# **OXFORDSHIRE COUNTY COUNCIL'S RESPONSE TO CONSULTATION ON THE FOLLOWING DEVELOPMENT PROPOSAL**

**Application no:** 15/00837/OUT

**Proposal:** OUTLINE - Residential development of up to 180 dwellings to include affordable housing, public open space, localised land remodelling, compensatory flood storage and structural planting

**Location:** Part Land On The North East Side Of Gavray Drive Bicester

Figure 9: View through the site - route of existing footpath

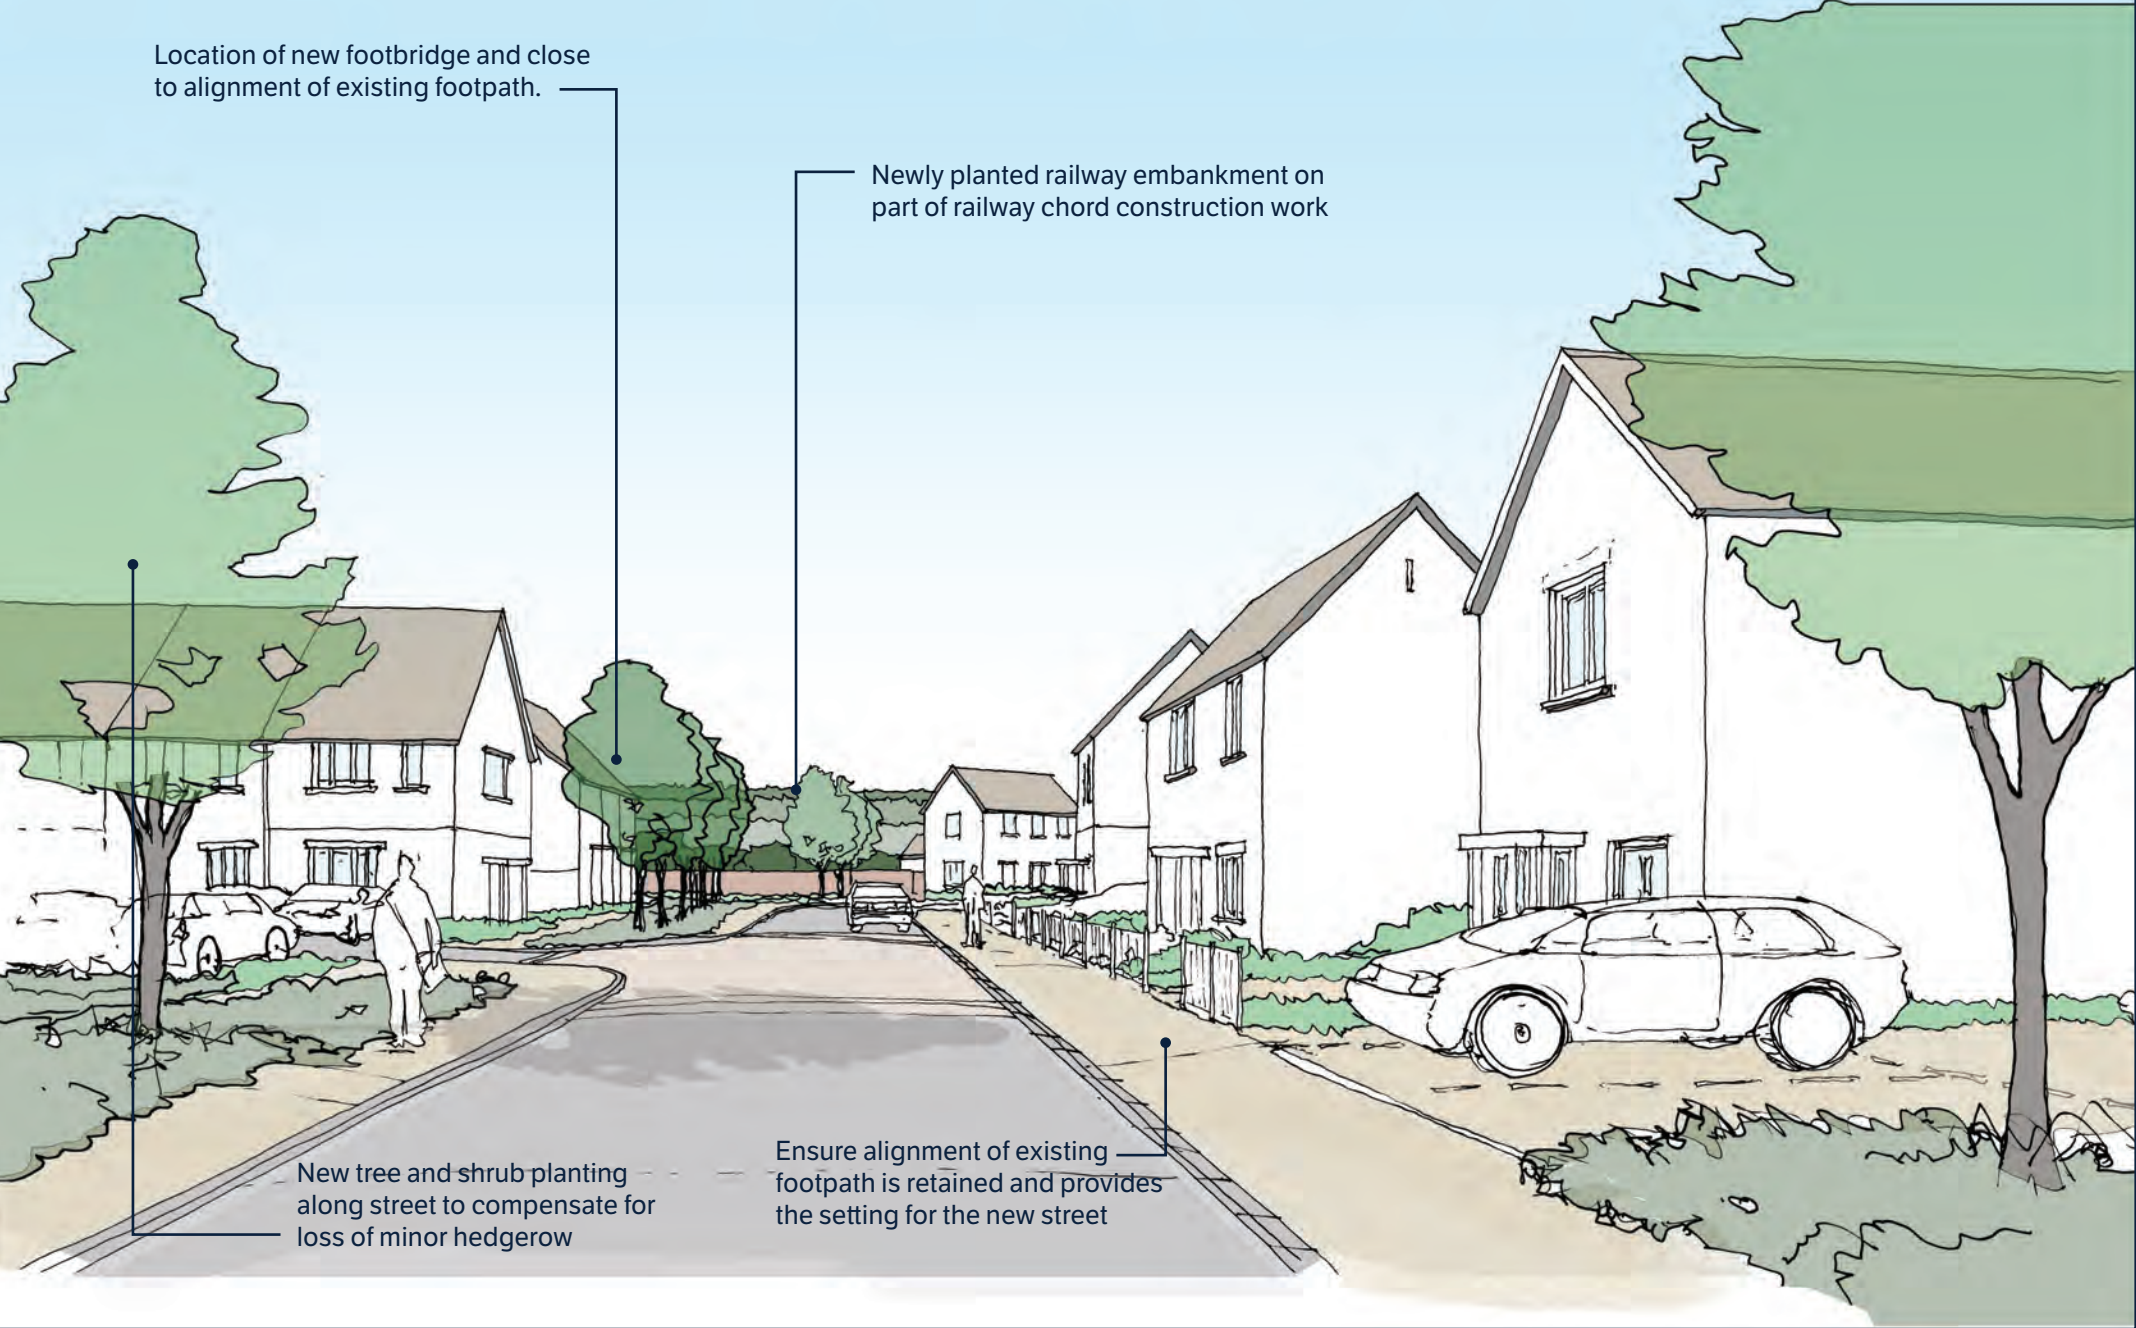
Within the site, connections should be provided through to the wider site, and the footpath towards the new footbridge over the railway will need to be surfaced and lit.

A footpath runs across the site and over the new footbridge across the rail chord (shown on the plans). The footpath will need to be diverted at the point where it runs over the railway bridge. A surfaced path must be provided by the developer to link to the steps of the footbridge.

Q:\14-033 - Gavray Drive, Bicester\Tech\Acad\Drawings\14-033-009 REV B Proposed Site Access.dwg

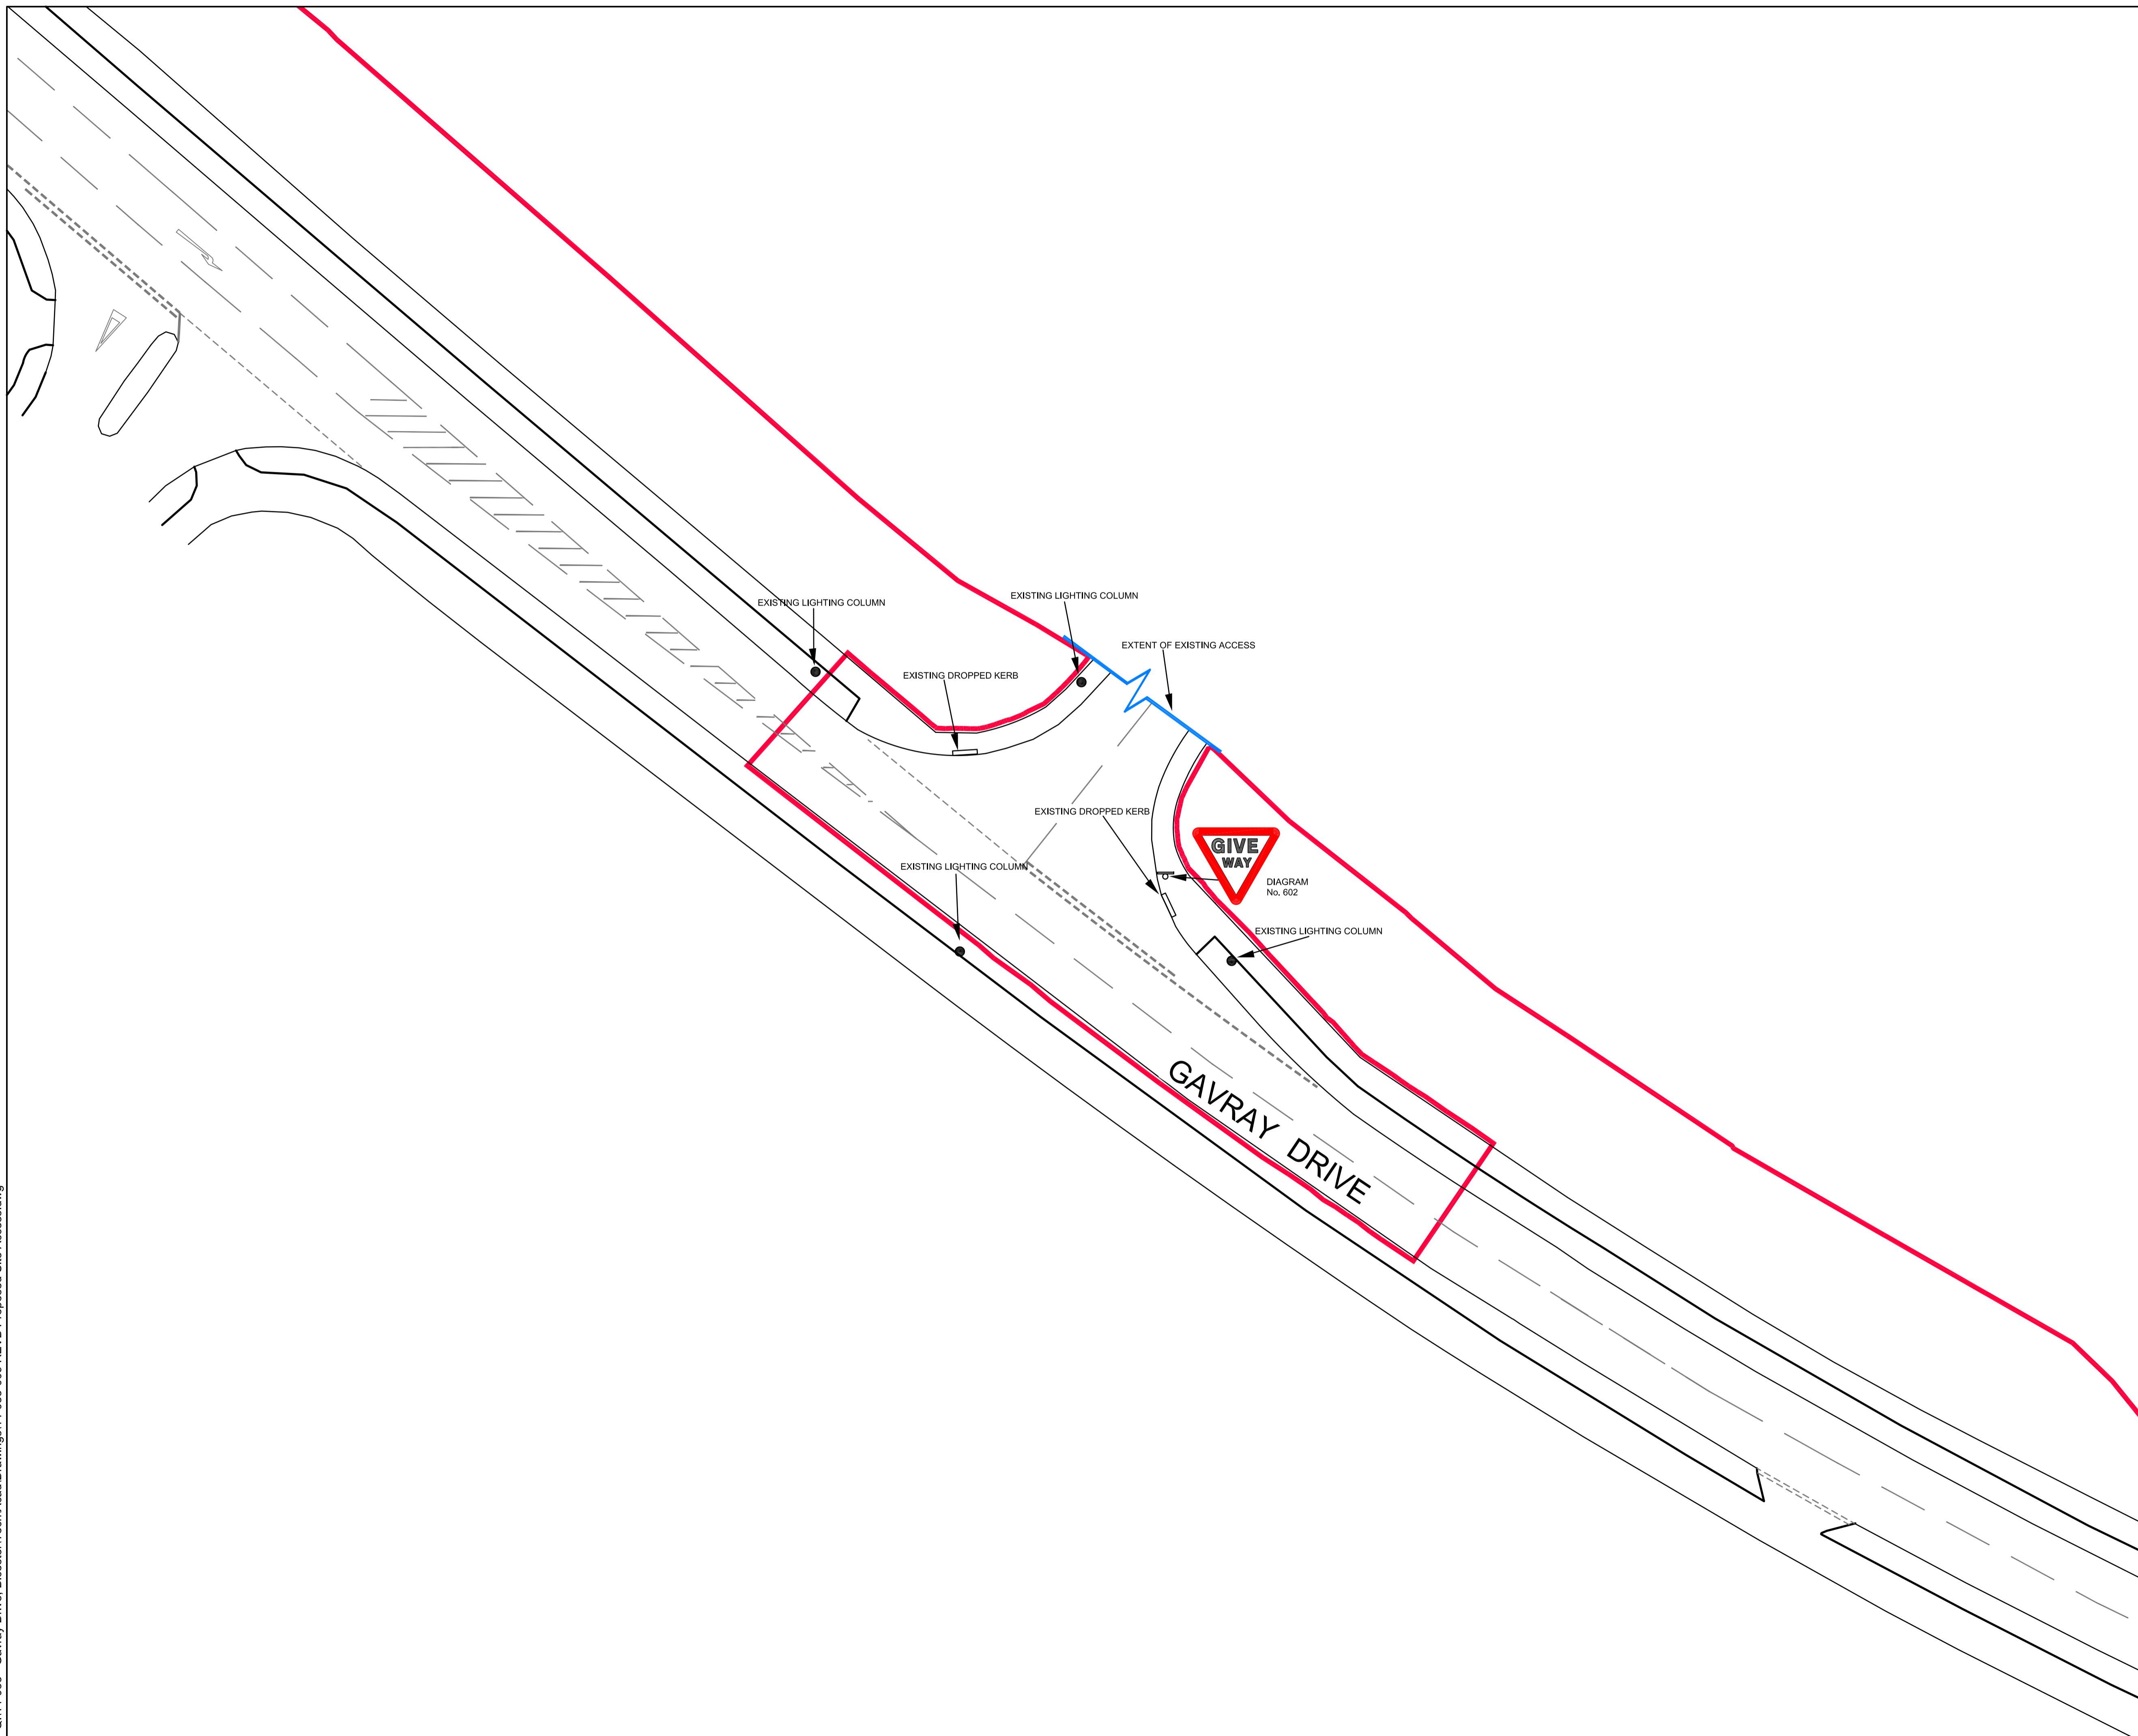
In terms of walking and cycling links, the TA lacks detailed information about how the development links into the local network. At scoping, a walking and cycling audit was requested, but this has not been carried out. Scoping also highlighted the need for local improvements, in particular crossings of Gavray Drive, which have not been addressed. To the north, it is noted that a ped/cycle access will be provided into the development, opposite the entry to the cycle track link to the town centre. Verge crossings and dropped kerbs will be required here. Consideration also needs to be given to the link towards the local centre in Langford Village, with appropriate crossings. Again, it is noted a ped/cycle access will be provided onto Gavray Drive south of the main vehicle access. Both these access points and crossing arrangements need to be included in the access arrangements, to be provided by the developer under S278, along with any other off-site pedestrian/cycle improvements identified by the audit.

Consideration should be given to cycle links towards Charbridge Lane heading north, including possible conversion of the footway on the east side of Gavray Drive to shared use, if a direct cycle route through the wider site cannot be provided.

- Infrastructure for of a pair of bus stops on Gavray Drive, adjacent to the development, inclusive of hardstanding areas and any connecting footways.
- Pedestrian and cycle access improvements on Gavray Drive including crossing points, plus minor off-site improvements as identified by a walking and cycling audit.
